KITTITAS COUNTY

MEMORANDUM

TO: All Staff
FROM: Public Works Plan Review Team
DATE: December 10, 2024- UPDATE Survey Review 12/23/2024
SUBJECT: SPF-24-00012 Sparks

**BOWERS ROAD SHORT PLAT
PART OF SECTION 26, T. 18 N., R. 18 E., W.M.
KITITAS COUNTY, WASHINGTON**

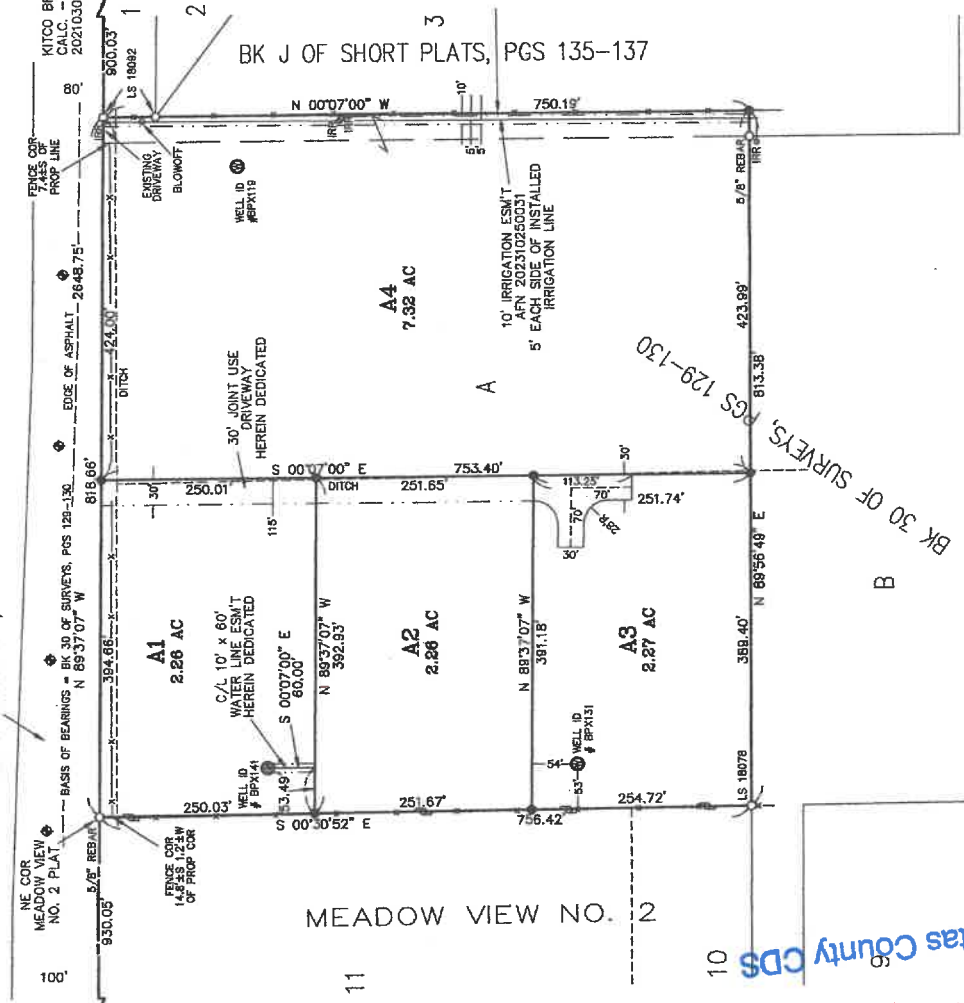
ACCESS	<ol style="list-style-type: none">1. An approved access permit shall be required from the Department of Public Works prior to creating any new driveway access or performing work within the county road right-of-way.2. Any further subdivisions or lots to be served by proposed access may result in further access requirements. See Kittitas County Road Standards.3. New access easements shall be a minimum of 30' wide. The roadway width shall have a minimum width of 12' if the length of the driveway is less than 150', or 16' if the length of the driveway is more than 150'.4. Driveways longer than 150' in length are required to provide a Fire Apparatus Road Turnaround meeting the requirements of Appendix D in the International Fire Code.5. Maintenance of the access is the responsibility of the property owners who benefit from its use.6. In addition to the above-mentioned conditions, all applicable Kittitas County Road Standards apply to this proposal. <p>NOTE: Existing Address 540 W. Bowers Rd is retained by residence Lot A4 upon recording of Short Plat Final.(RC)</p>

FLOOD	No comments. (SC)
WATER MITIGATION/ METERING	Water mitigation and metering requirements for final plat have been satisfied. No additional comments. (SC)
AIRPORT	<ol style="list-style-type: none">1. Include the following plat note per KCC 17.75.030 The subject property is presently located in the vicinity of an airport, within what is known as an airport influence area. For that reason, the property may be subject to some of the annoyances or inconveniences associated with proximity to airport operations (for example: noise, vibration, or odors). Individual sensitivities to those annoyances can vary from person to person.2. Development is located within the safety zone Inner Turning Zone 3 of runway 7-25. Please note requirement of KCC 17.58.060(1)(d) of recording the following notice: This property is located adjacent to an airport and routinely subject to overflight activity by aircraft using the airport; residents and tenants may experience inconvenience, annoyance, or discomfort from noise, smell or other effects of aviation activities.3. Please include a plat note requiring individual structures to file FAA form 7460 Notice of Proposed Construction or Alteration as currently required, or as amended.
